Application for a non-material amendment following a grant of planning permission.  
Town and Country Planning Act 1990

Alterations and single storey extensions to existing dwelling with new annex

PF/23/0299

Total of three additional rooflights added to ground floor bedrooms

Drawing Title: **Proposed Roof Plan**

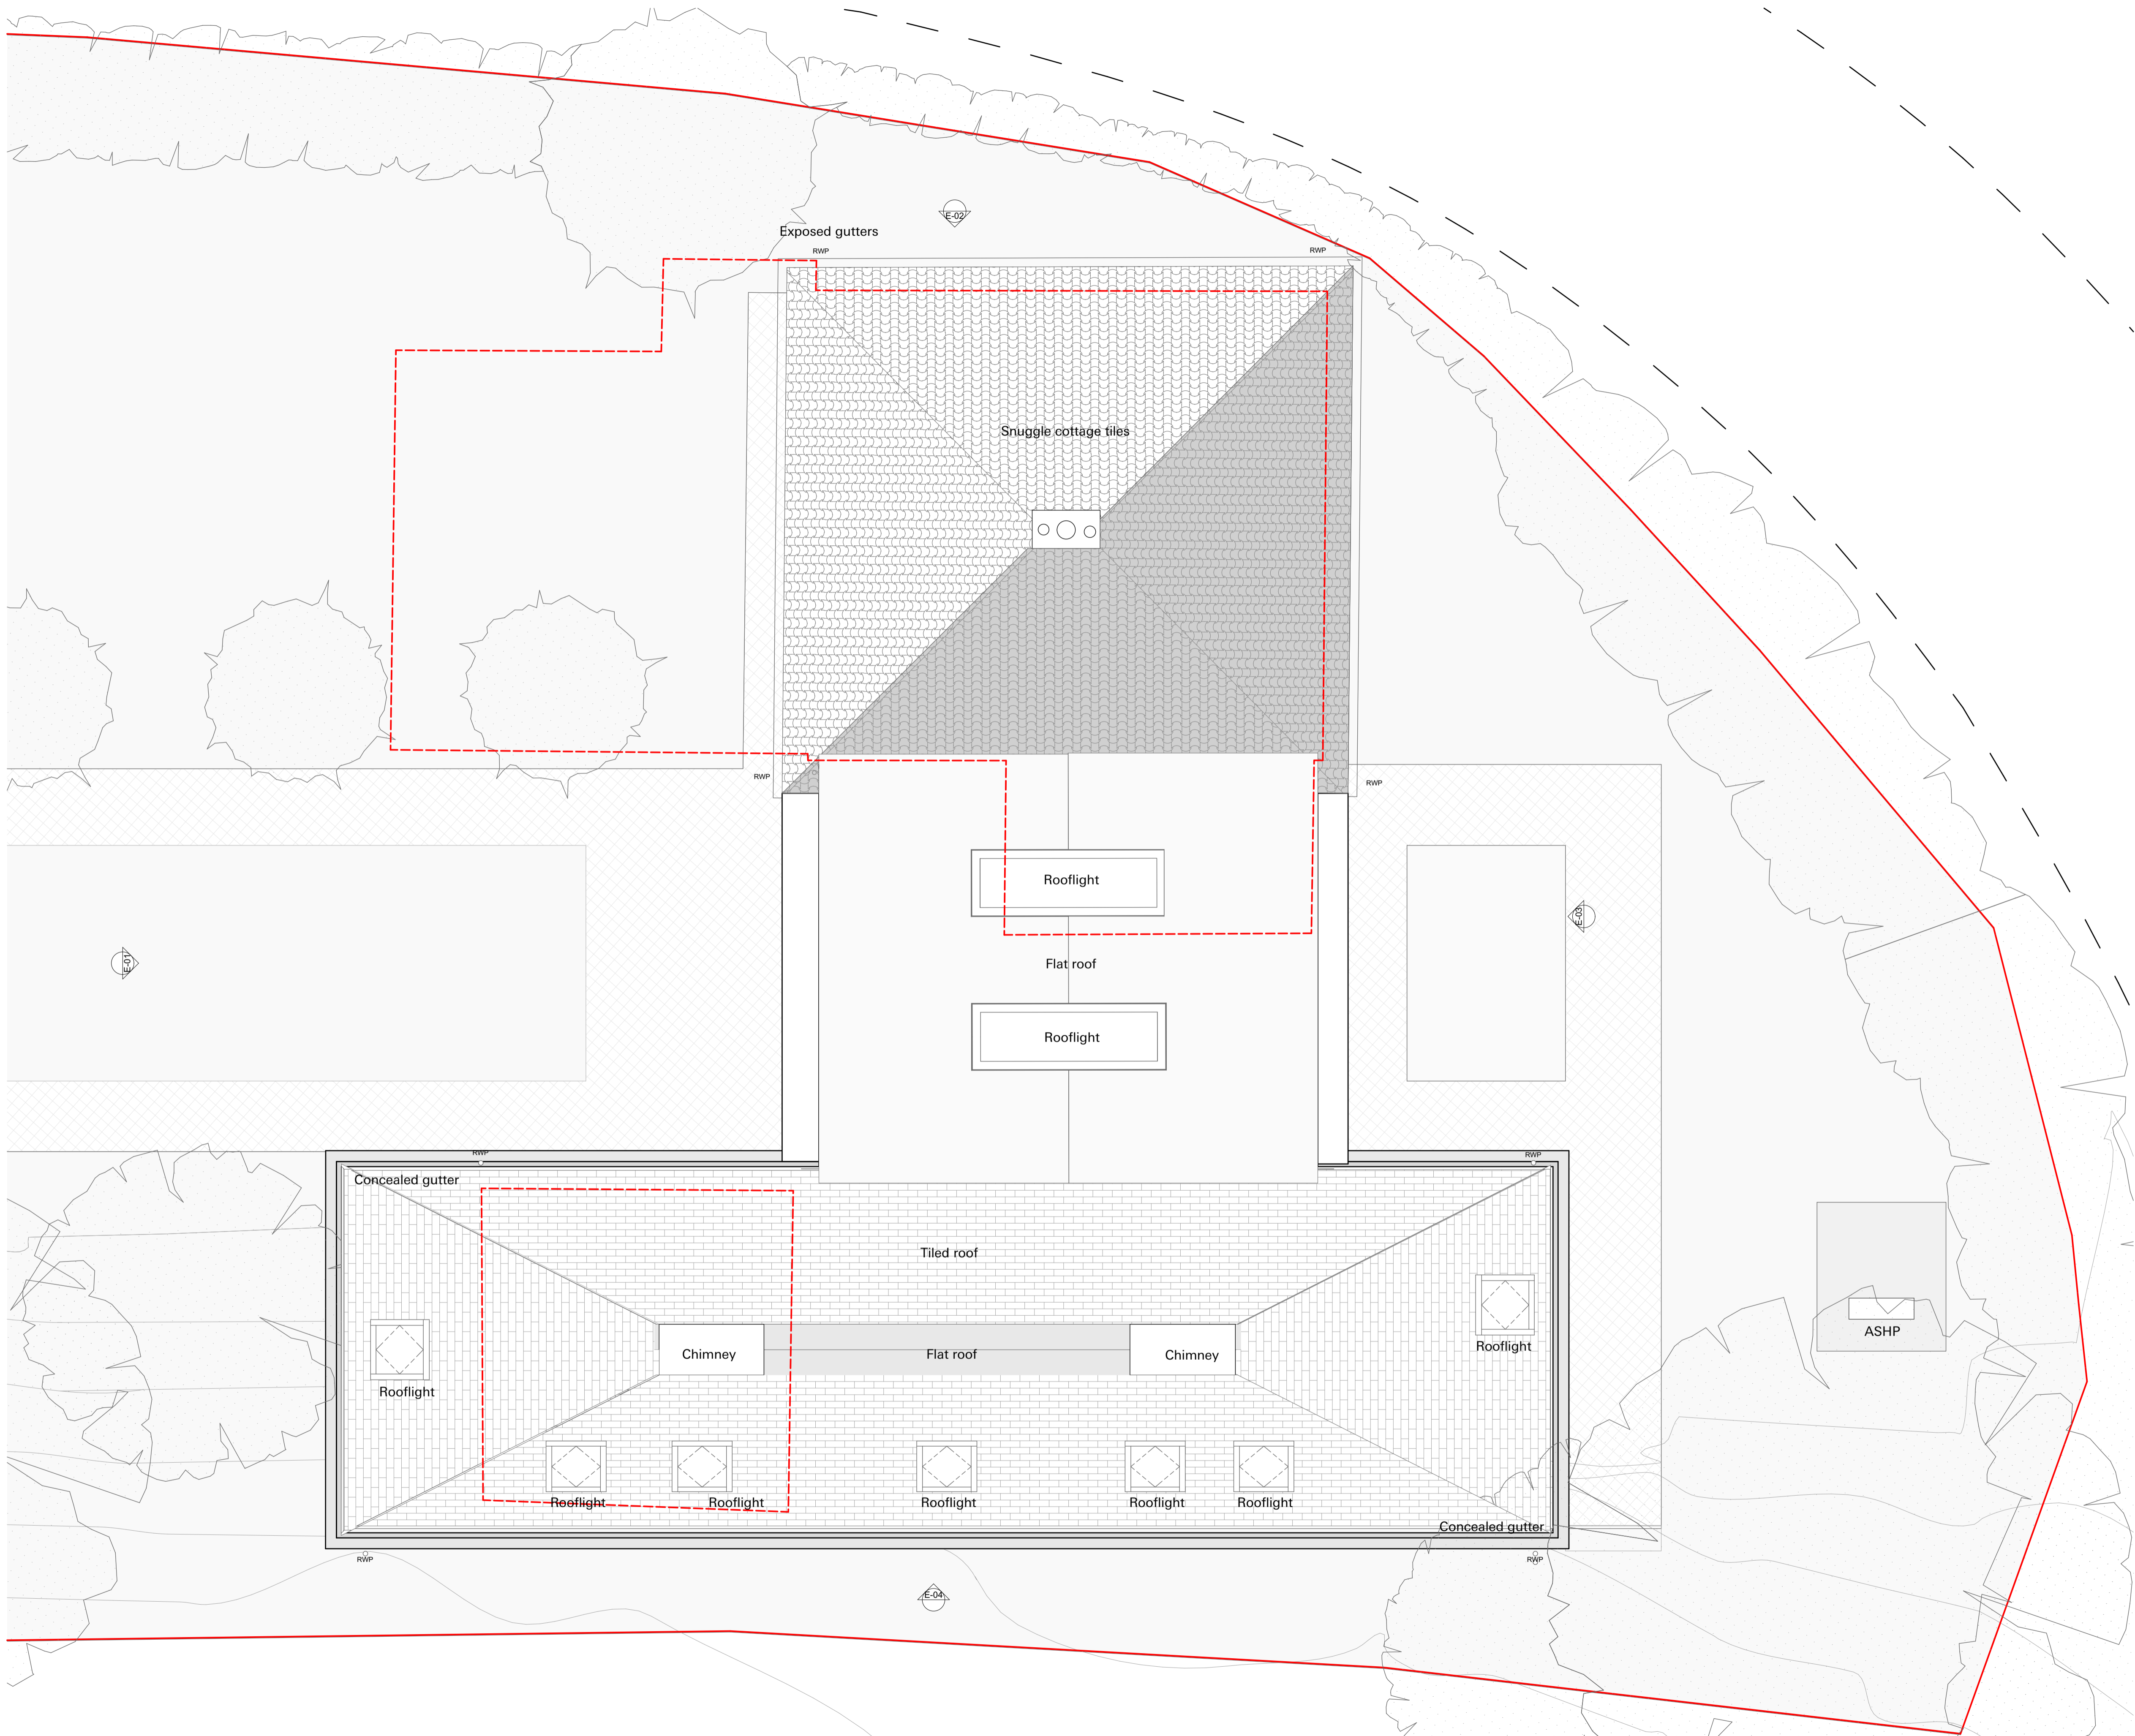
To provide secure night time ventilation to bedrooms to comply with Building Regulations

SC\_00\_2001\_Proposed Roof Plan (Rev. B)
